Plan Amendment - 3 Story Conversion

RE: Staff Review Comments for Amendments to Approved Plans for 130 Eastern Promenade

Project Name: 130 Eastern Promenade Plan Amendments
Address: 130 Eastern Promenade
Applicant: Eileen Simko-Minte
Planner: Nell Donaldson

Project ID: 2013-236
CBL: 003 C001001

SITE GRADING
PLAN

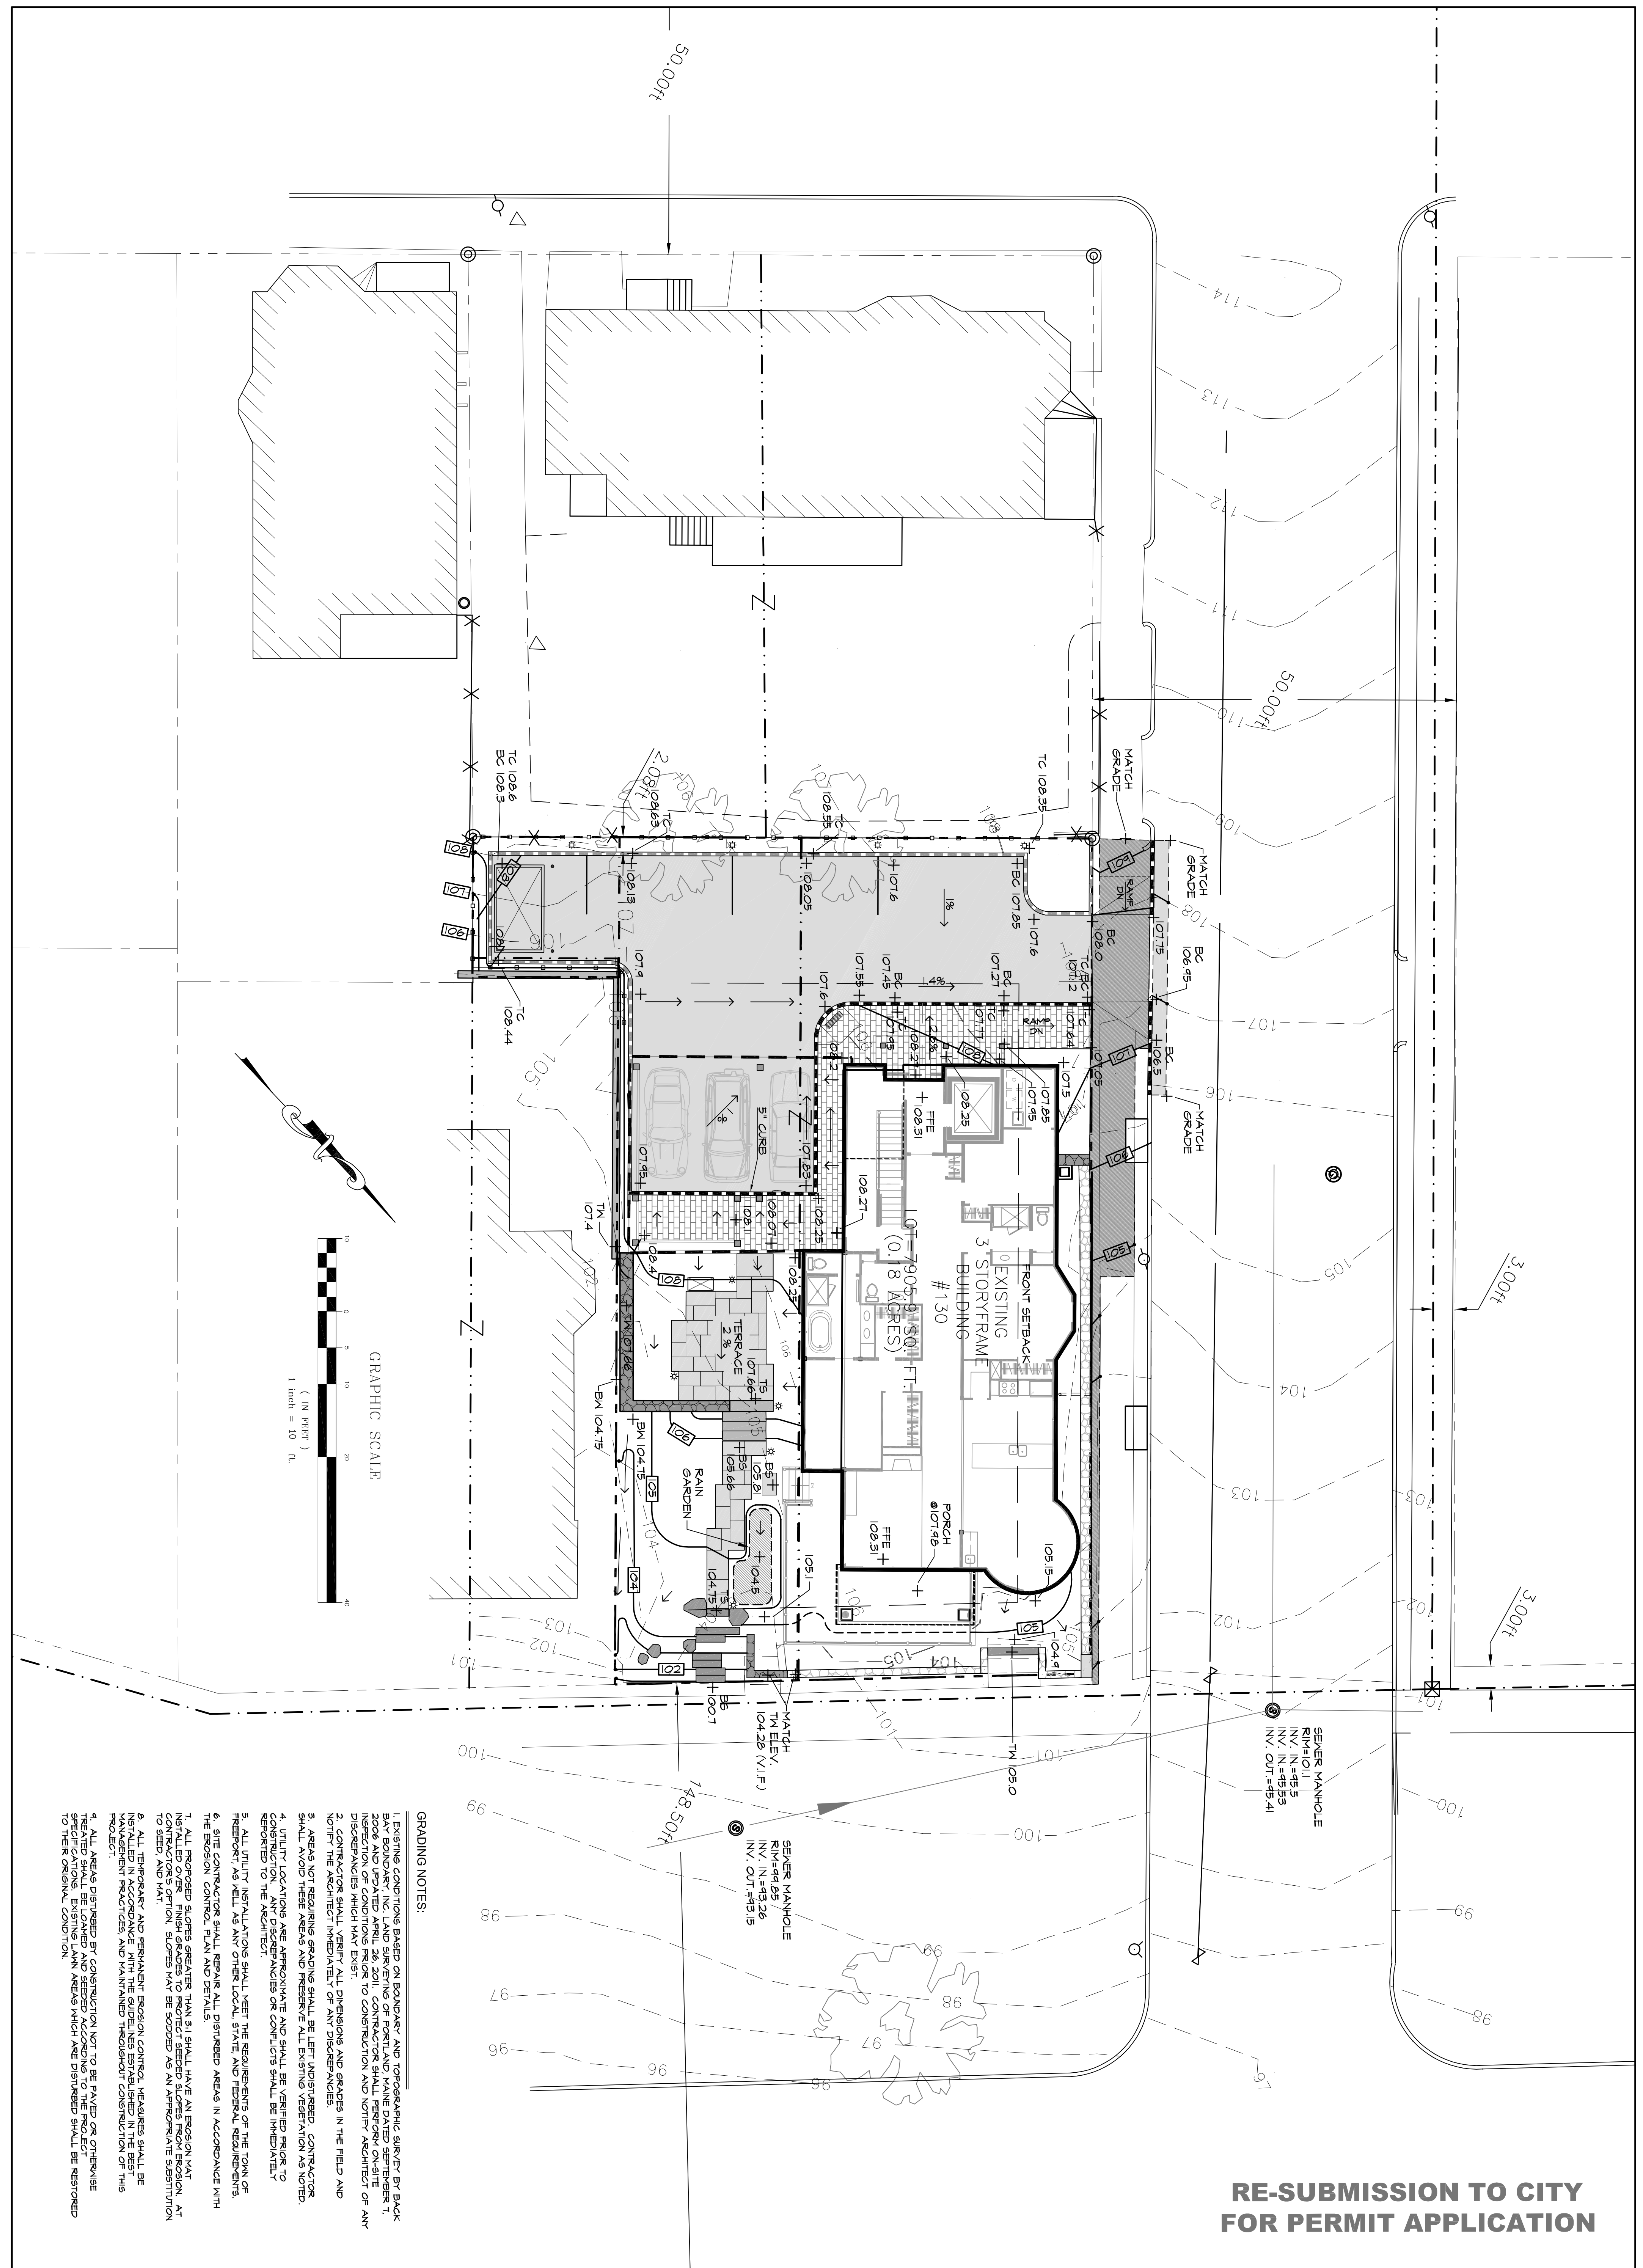
The rain garden details on sheet D-1.0 and the retaining wall detail on L-5.1 indicate that an underdrain will exist below the rain garden and at the base of the retaining wall; however, no underdrains are depicted on the site plans. If an underdrain is required for these systems, we encourage day-lighting the underdrain(s) in lieu of a direct connection to the combined sewer; clarification should be provided on the plans and/or details.

1 SHRUB PLANTING DETAIL  
NOT TO SCALE

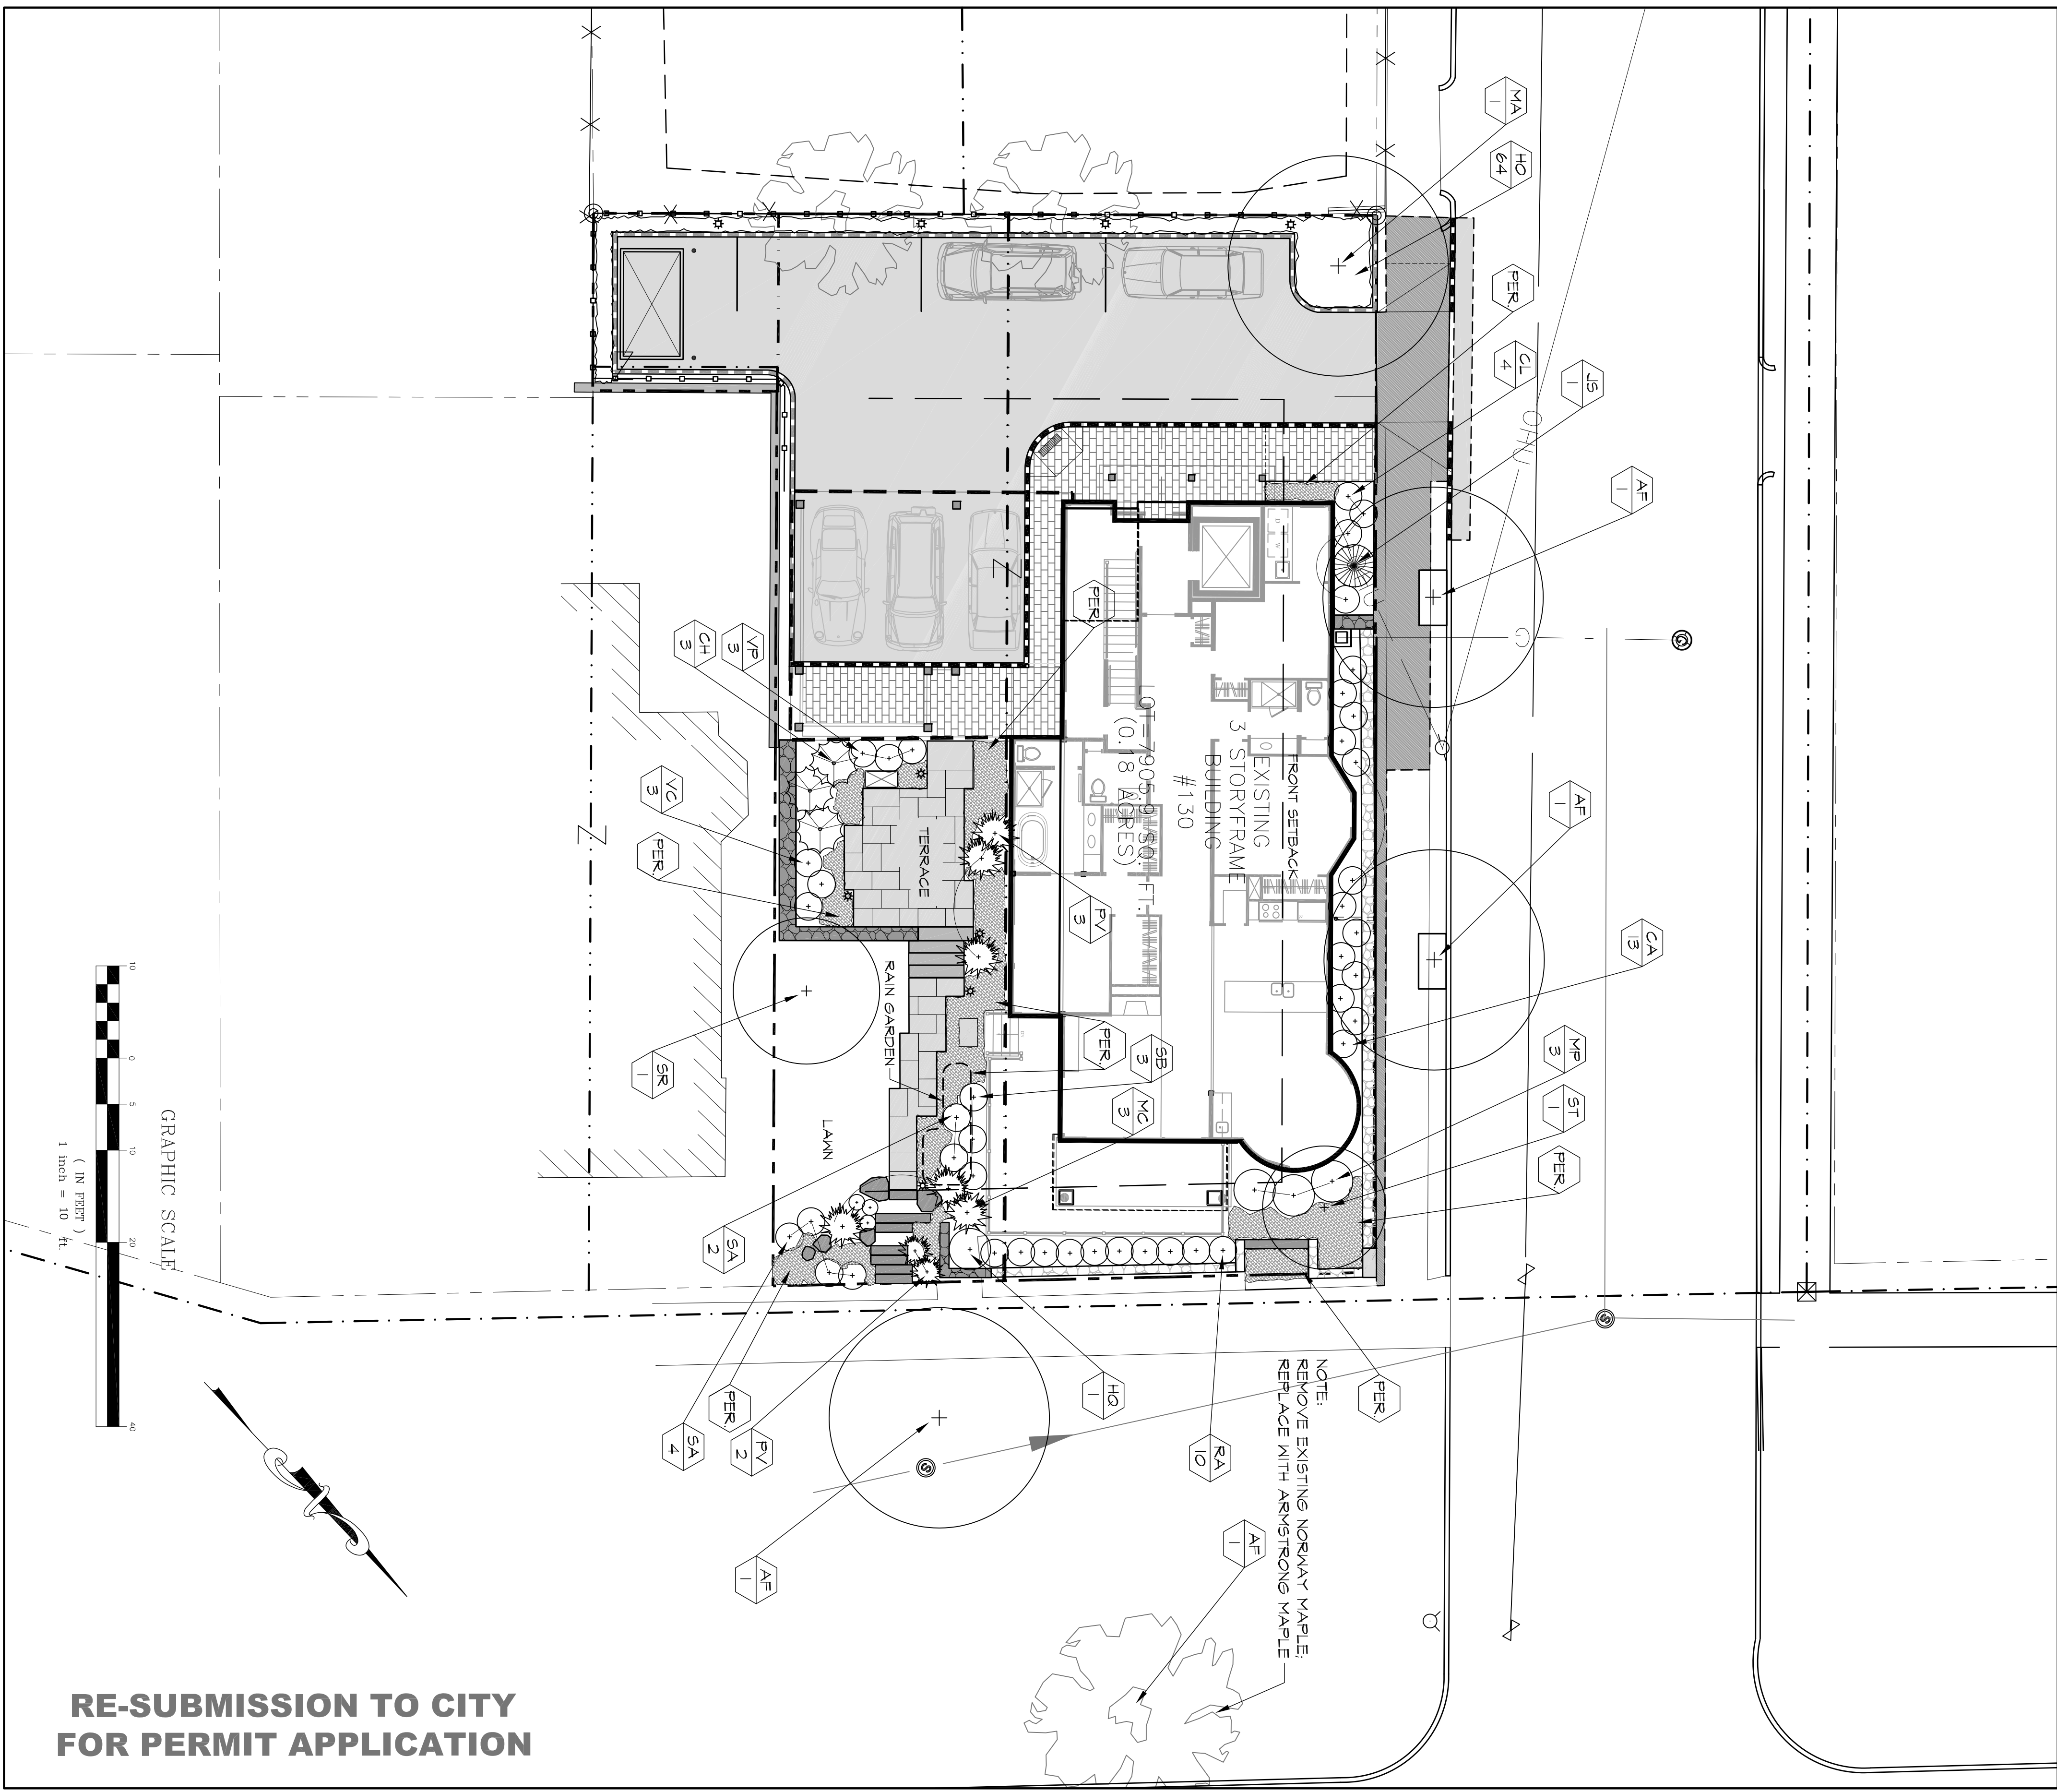
✓ The project proposes two new street trees along Wilson Street. Due to overhead utility lines overhead on the second tree (away from E Prom) that tree should be a smaller tree such as Sargent Cherry, Japanese Tree Lilac vs the 'Armstrong' Red Maple as shown. The maple is good for the tree closest the prom with no overhead wires.

✓ Review and increase plant sizes for the 1 gallon plant sizes to 3 gallon size on 'Gro-low sumac, the crab-apple recommendation would be "Adirondack". Options for the proposed Japanese Tree Lilac could also be dogwood or crab-apple.
